SICEEP – North West Plot SSDA4 - Response to Public Submissions

21st September, 9am

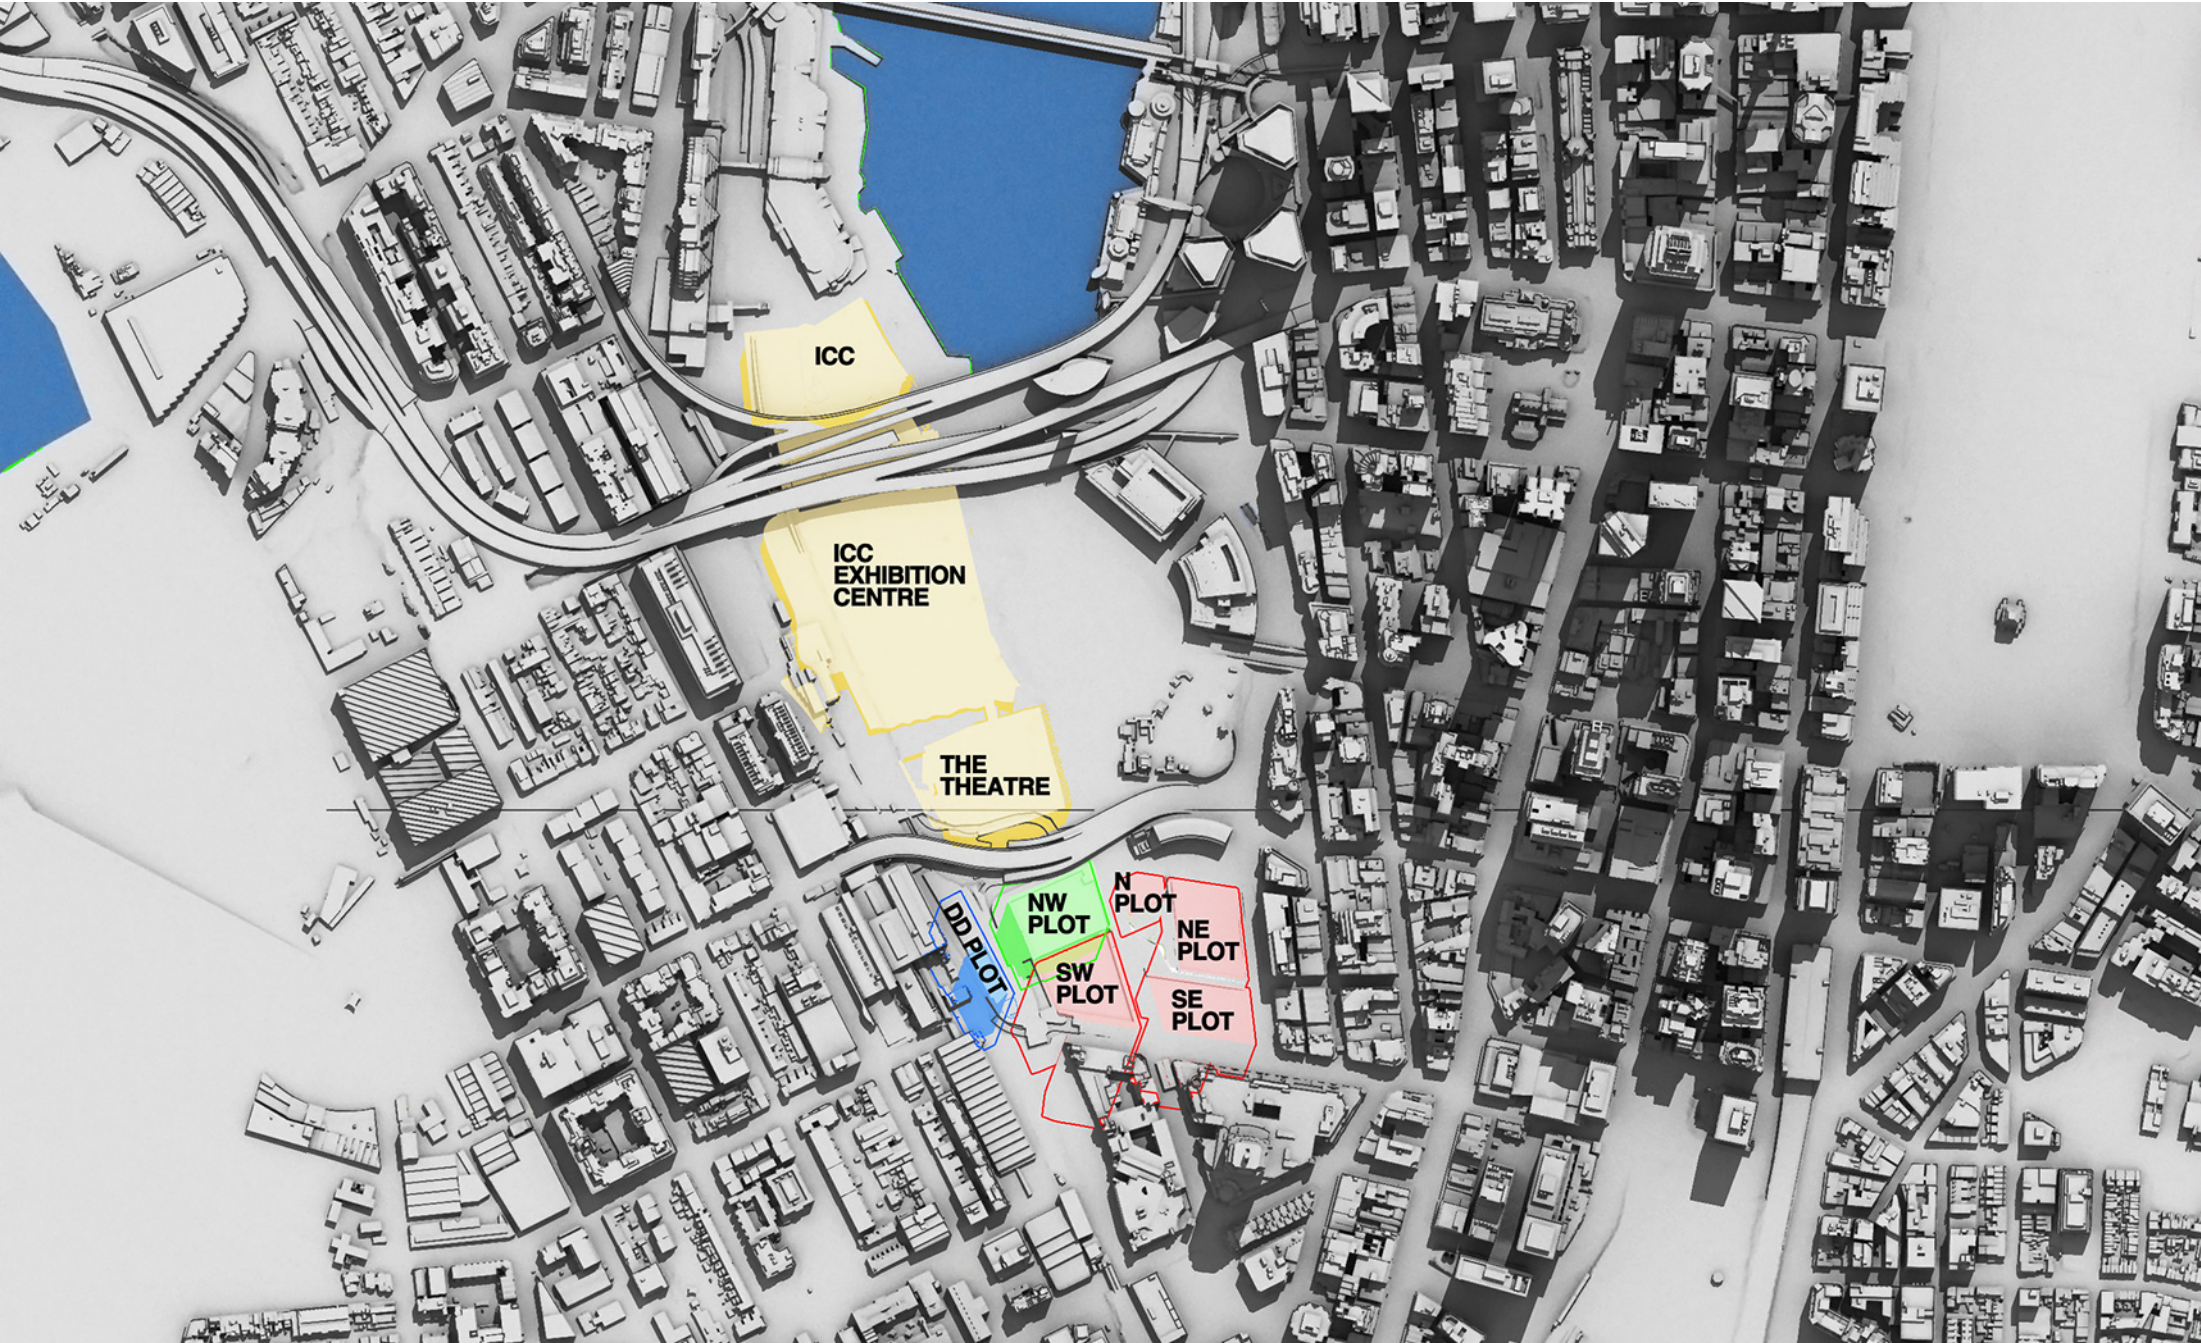
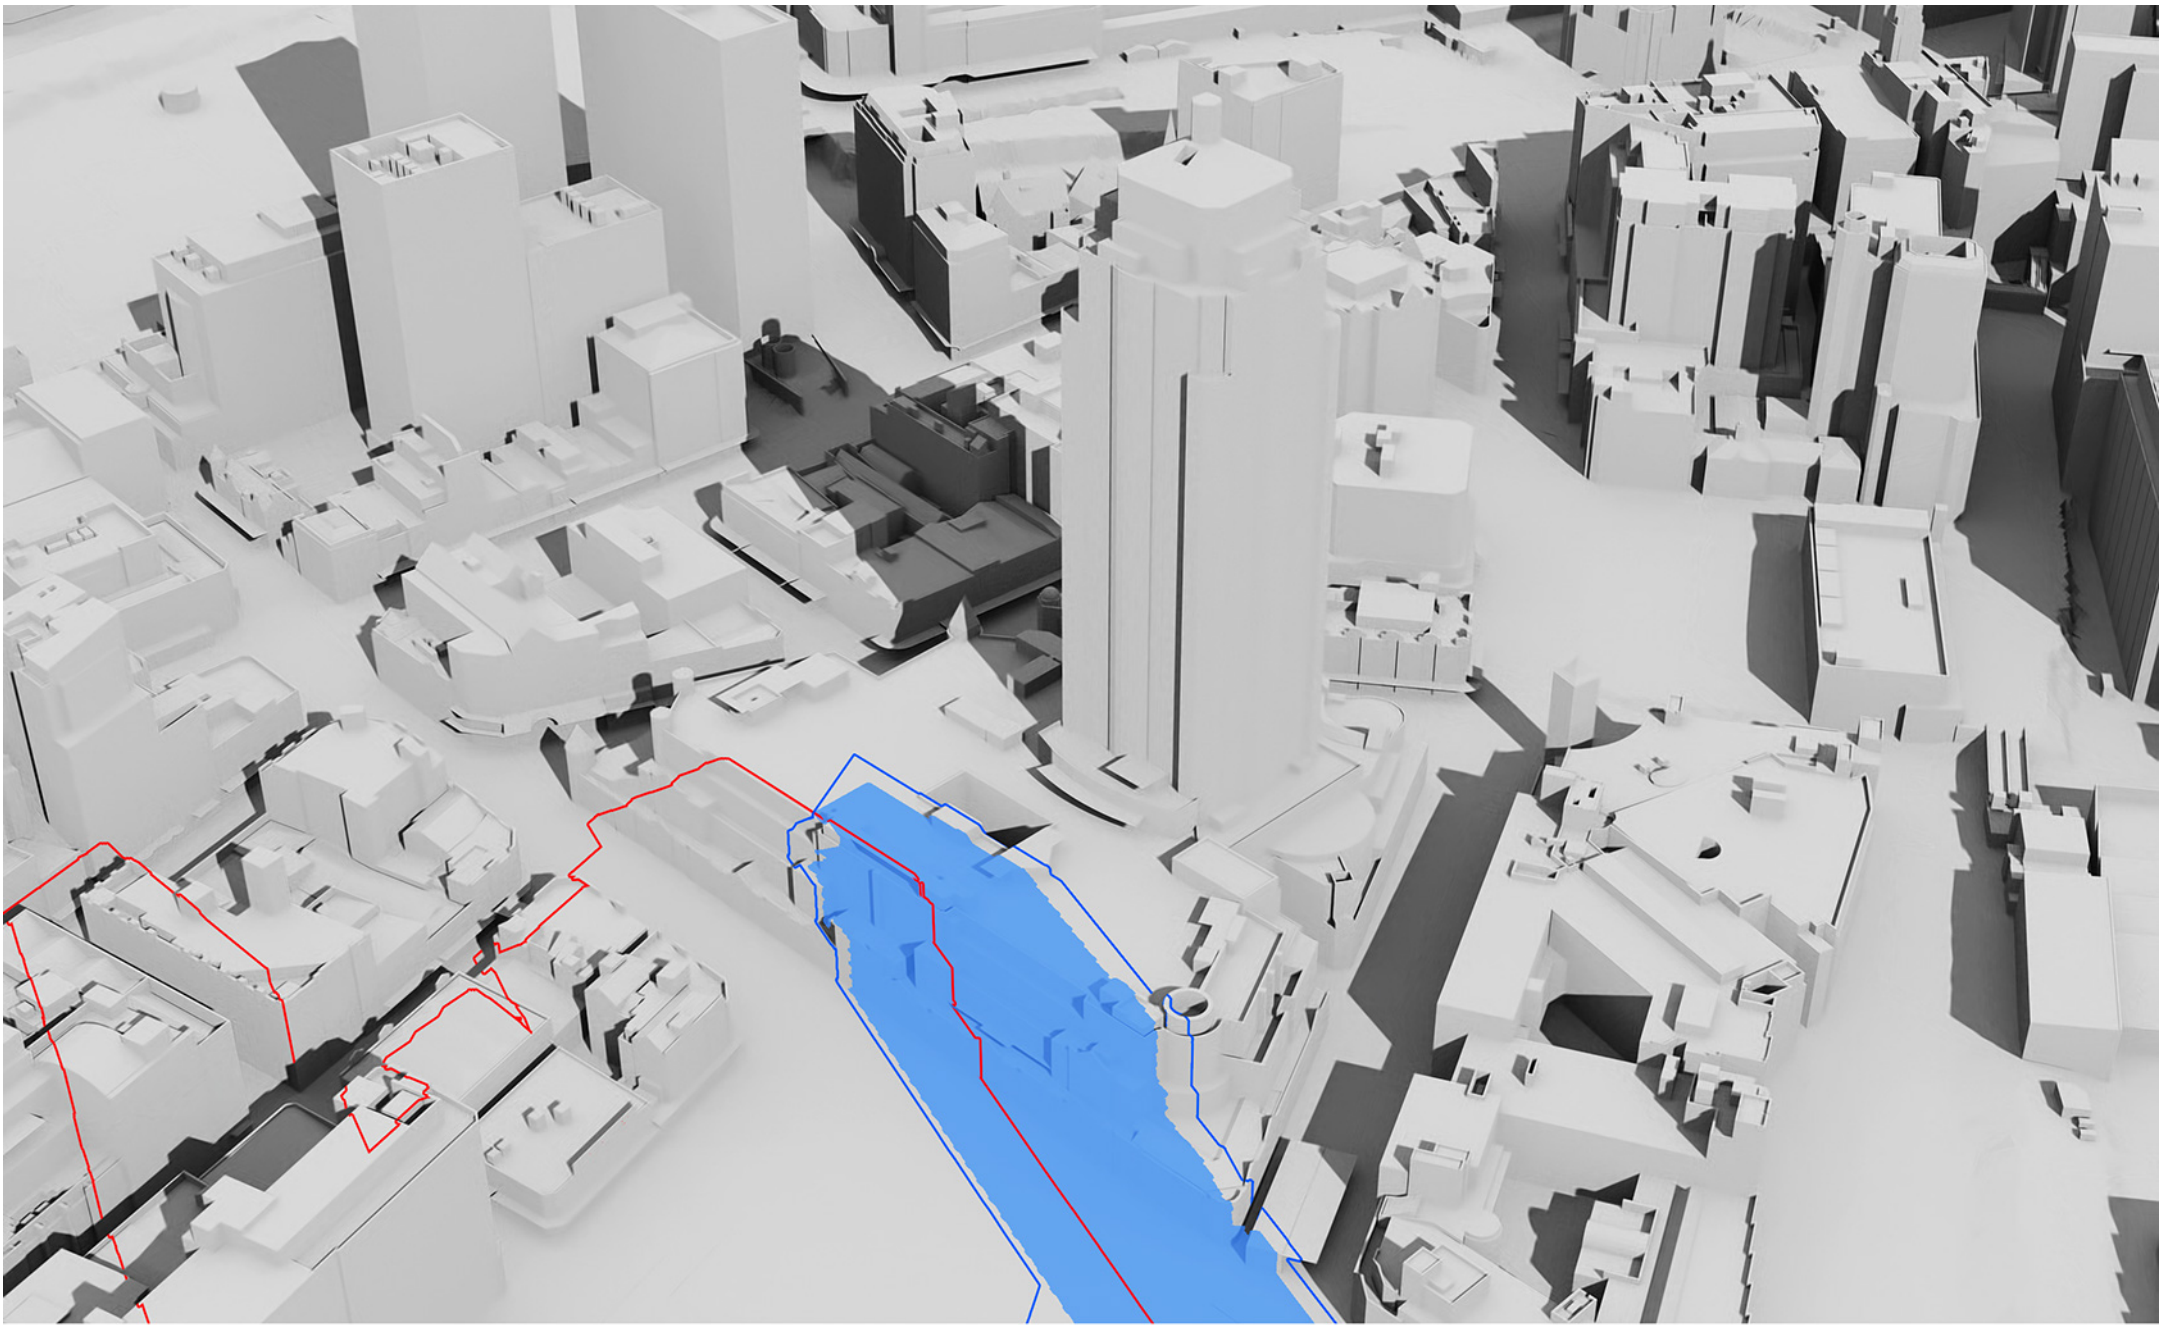
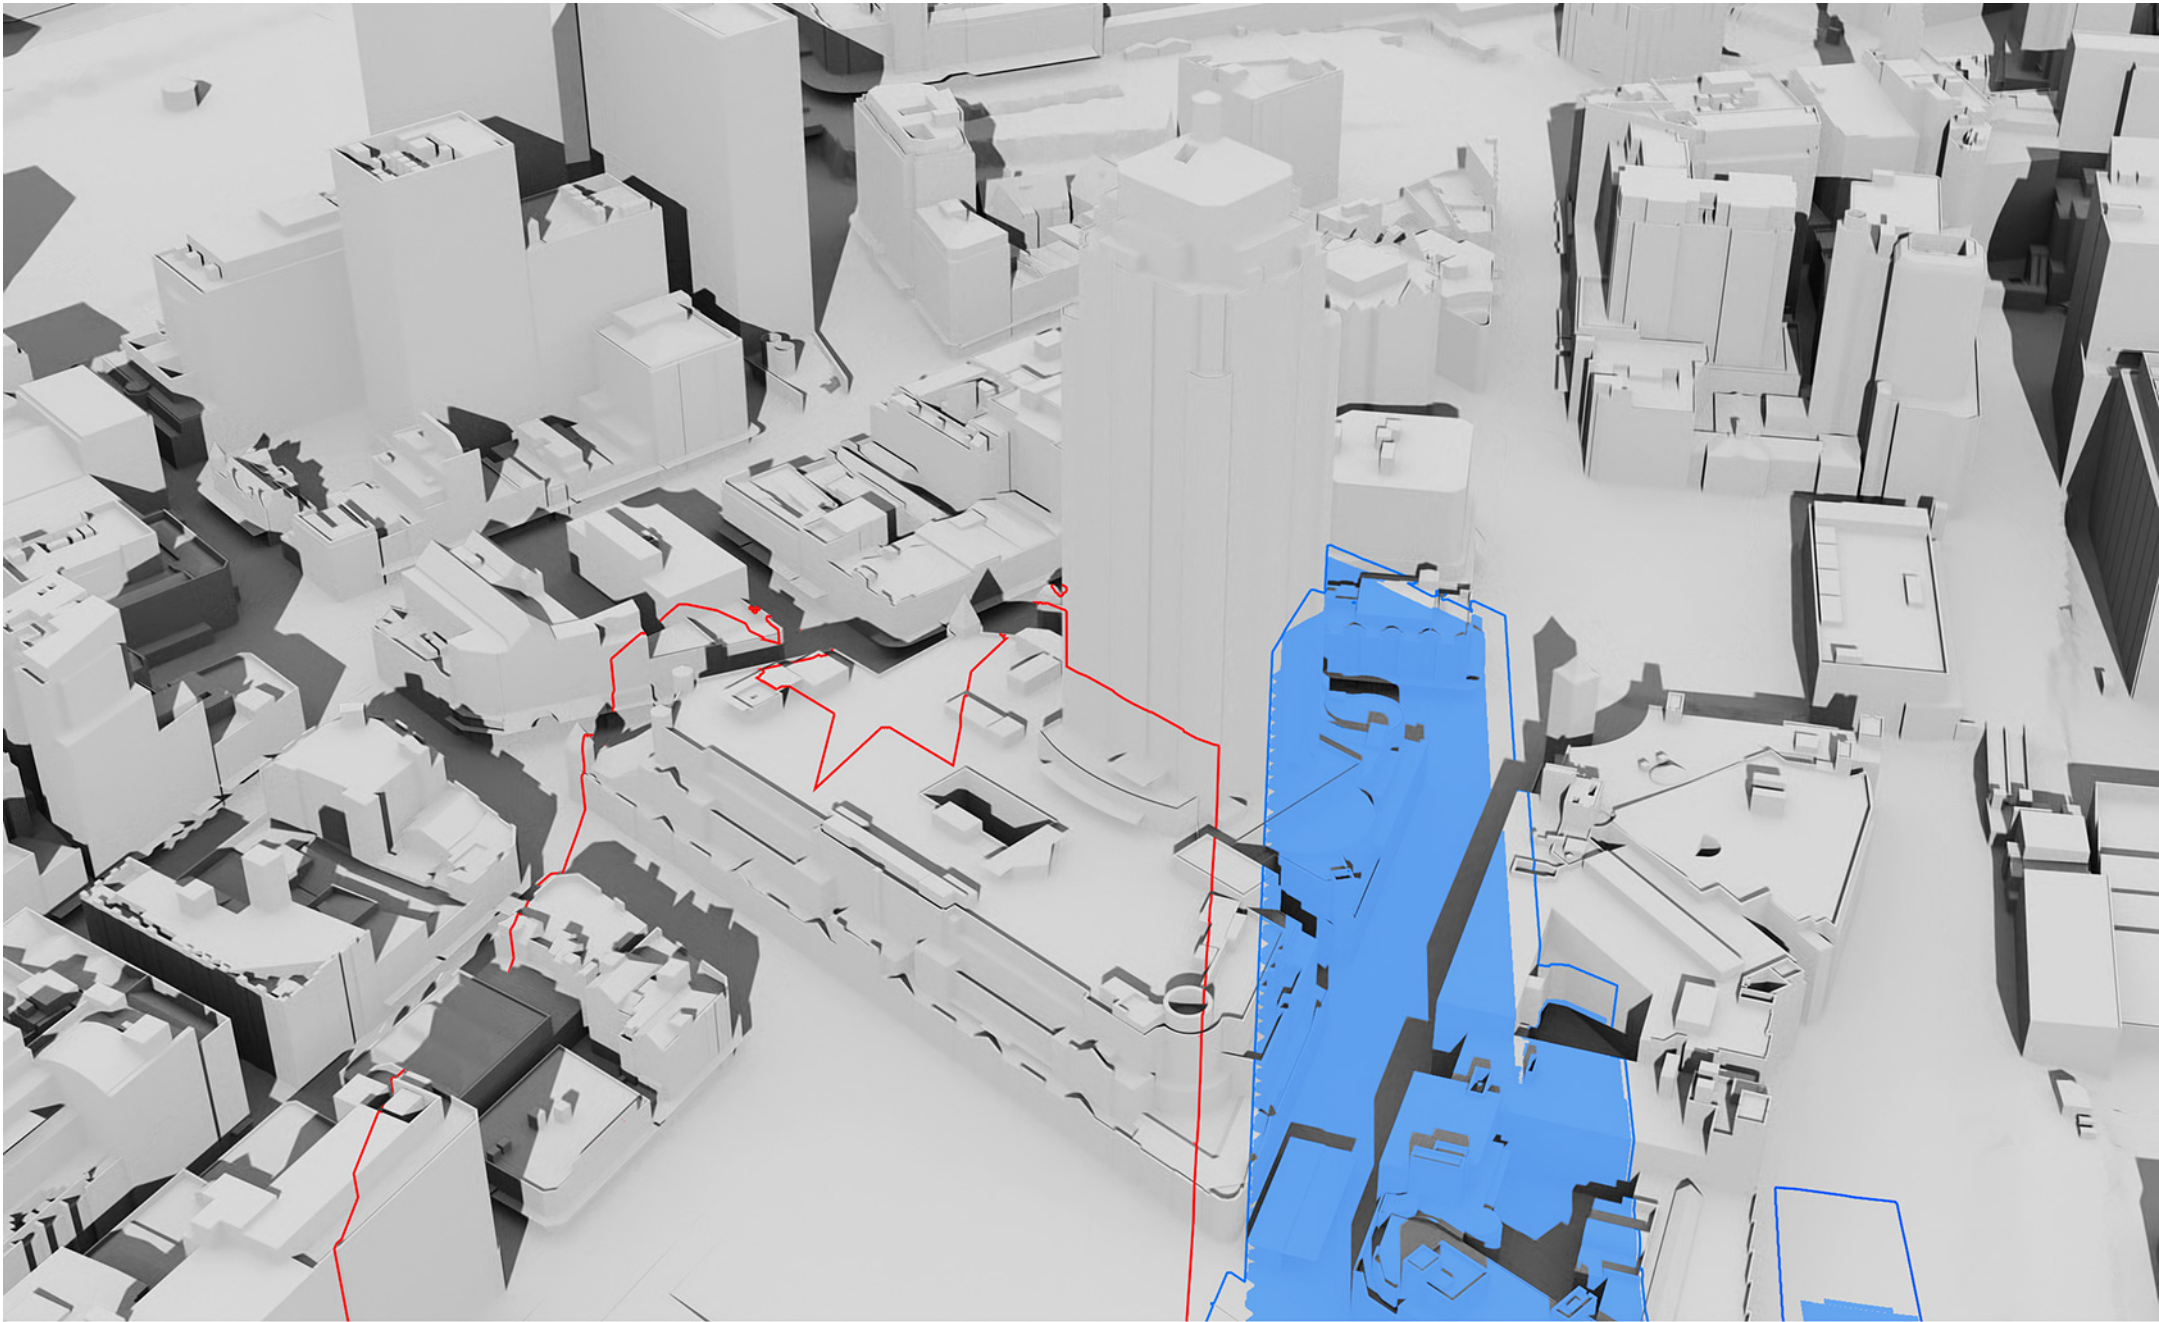
Number of times raised in Submissions	Item Raised	Proponent's Response
Overshadowing		
2	Contrary to the requirements of the City of Sydney Development Control Plan 2012 (DCP), the overshadowing diagrams in the original EIS were in plan only (Appendix J, pages 74-80). The original EIS did not include any overshadowing diagrams in elevation. Therefore it was impossible to assess the extent of overshadowing of individual neighbouring dwellings within tall buildings, ie The Peak and The Quay. The elevation studies have now been belatedly provided during the Stage 2 SSD's exhibition phase and meaningful public response is now possible for the first time. For some reason, exhibition of the Stage 2 SSDs did not wait until the revised EIS was publicly available. Therefore although this submission is being made in response to the Stage 2 SSDs, it necessarily focuses on the shadow diagrams in the revised SSD 5878. It is important to note that those elevation studies do flow through to each of the Stage 2 SSDs. As at the date of this submission, SSD3010, SSD6011 and SSD6013 are the only SSDs on exhibition for The Haymarket site.	There was no statutory requirement as part of the submission of the Stage 1 Development Application (SSD_5878) to prepare and submit elevational shadowing diagrams, noting that the Sydney DCP does not apply to the SICEEP site. Notwithstanding and in response to submitters and the Department of Planning and Infrastructure, detailed shadow diagrams were subsequently prepared illustrating the shadows cast by the Haymarket Concept Proposal on the facades of the Peak Apartments building. The shadow studies revealed that the extent of additional overshadowing as a result of the Concept Proposal (including the North West Plot which accommodates the subject mixed use commercial office building and public car park) is appropriate and reasonable. This conclusion was subsequently agreed with and supported by the Department of Planning and Infrastructure, with the Stage 1 Concept Proposal (SSD_5878) approved on 5 December 2013. With the subject State Significant Development Application (SSD_6013) being wholly contained within the approved building envelope for the North West plot, the overshadowing impacts resulting from the proposed Mixed Use Commercial Office Building and Public Car Park are appropriate and consistent with the Stage 1 approval.

2	The assertion made within SSD5878 Response to Submissions and Amendments to Proposed Development Report, July 2013, that the apartments on the northern and western elevations of the building are dual aspect is incorrect. Only corner apartments are dual aspect, with levels of the tower containing single aspect apartments on all elevations.	Noted. Notwithstanding the proportion of single aspect apartments within the Peak building, the level of additional overshadowing impacts remains acceptable as demonstrated within the detailed shadow studies submitted in support of the Stage 1 Concept Proposal (SSD_5878). This conclusion was subsequently agreed with and supported by the Department of Planning and Infrastructure, with the Stage 1 Concept Proposal (SSD_5878) approved on 5 December 2013.

Number of times raised in Submissions	Item Raised	Proponent's Response
2	It is disappointing that at this late stage in the development application process, despite numerous site visits by the proponent, and despite the apartment aspects being publicly available from NSW Land and Property Information, the proponent is still unaware of the actual apartment aspects within The Peak. In total there are 110 apartments in The Peak with single aspects which are either west only or north only. 110 apartments with single aspects which are either west only or north only is hardly a negligible number whose existence can be falsely denied by the proponent.	Noted. Notwithstanding the proportion of single aspect apartments within the Peak building, the level of additional overshadowing impacts remains acceptable as demonstrated within the detailed shadow studies submitted in support of the Stage 1 Concept Proposal (SSD_5878). This conclusion was subsequently agreed with and supported by the Department of planning and Infrastructure, with the Stage 1 Concept Proposal (SSD_5878) approved on 5 December 2013.

2	The proponent provides diagrams but fails to discuss the existing shadowing of the west façade of The Peak. The proponent provides diagrams but fails to discuss the combination of the proposed development with existing shadowing of the west façade of The Peak. It can be concluded that, as a result of combination of the proposed development with existing shadowing of the west façade, some single aspect apartments on the west façade and the south-west dual aspect corner apartments which currently receive less than 2 hours direct sunlight to habitable rooms and 50% of the private open space between 9am and 3pm on 21 June will suffer additional overshadowing. Rather than counting the number of units which will not meet the DCP guidelines, the proponent attempts to trade-off direct sunlight at 4pm for lack of direct sunlight during the period 9am to 3pm. There is no provision in the DCP guidelines for such a trade-off.	The Sydney DCP does not apply to the SICEEP site. The existing shadow impacts caused by the Peak building itself on apartments, in particular apartments on the southern and western elevations are noted. An assessment was undertaken in relation to the direct additional overshadowing impacts resulting from the Concept Proposal, with the results revealing that impacts would be acceptable and that apartments within the Peak would continue to receive an acceptable level of sunlight/daylight. In addition, we note that solar access is but one consideration in terms of residential amenity, with other equally important aspects to residential amenity (as prescribed under the Residential Flat Design Code) including views, outlook, access to services, transport, jobs etc. Therefore, notwithstanding some additional (acceptable) overshadowing impacts to apartments on the western elevation of the Peak building, these need to be considered holistically in terms of the other aspects of residential amenity afforded to these apartments.
